Consultee Comments for Planning Application 21/02930/DIC

Application Number: 21/02930/DIC

Address: 5 Olivers Battery Gardens Olivers Battery SO22 4HF

Proposal: Discharge of conditions 2, 3, 4, 5, 6, 7 and 8 of planning application 18/02699/FUL

Client: Mr and Mrs Conway	Building regs
Project: New dwelling at 5 Olivers Battery Gardens SO22 4HF	Drawing No: 235-03-02-001
Title: Proposed site plan	Revision: B
Scale: 1:50@A1	First Issue:

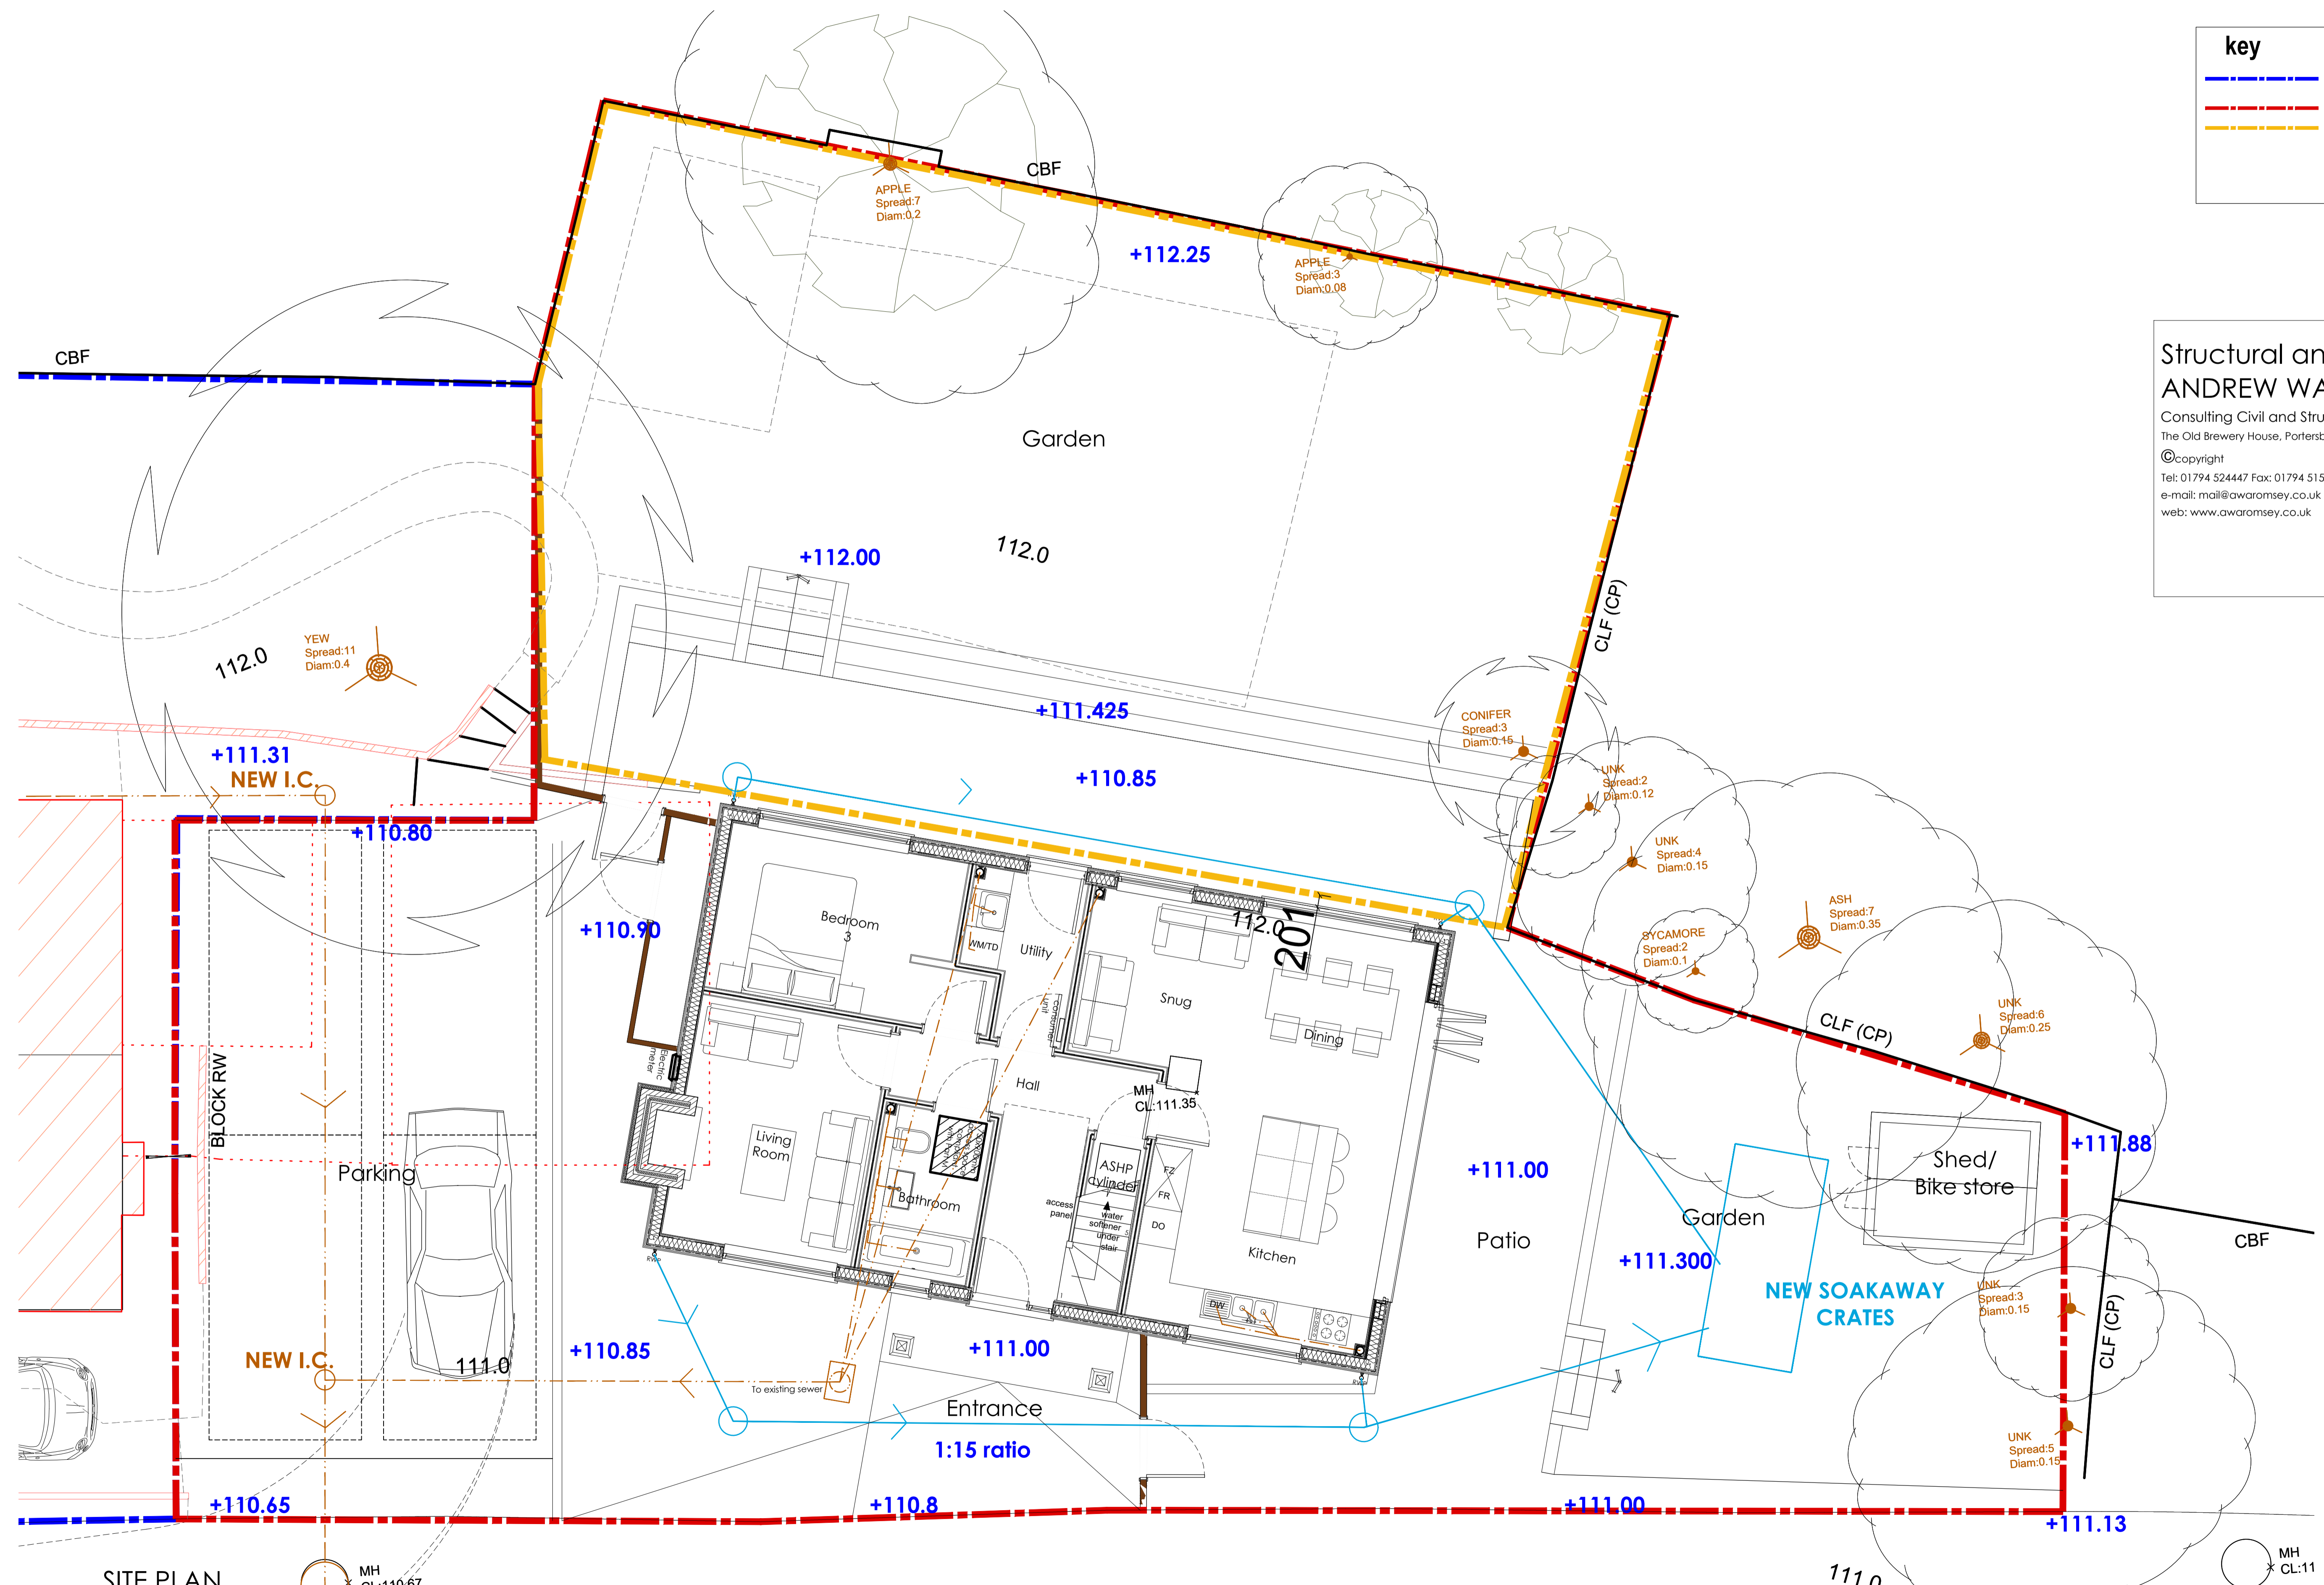
Application shows that they intend to discharge their foul to the main foul system by a gravity connection to the existing lateral, this is the most sustainable solution, they have a right to communicate with the main sewer, and SW wouldn't ask for a capacity check for just one property, so I find this proposal acceptable.

The application states surface water going to a soakaway on their own land, the site is on chalk so has good drainage, and infiltration is the most sustainable method, as long as the soak away has been sized to established guidelines with regards to rainfall, impermeable areas, infiltration rates climate change etc then again I find this proposal acceptable.

I have no objections to the proposed drainage solutions as long as they meet build regs.
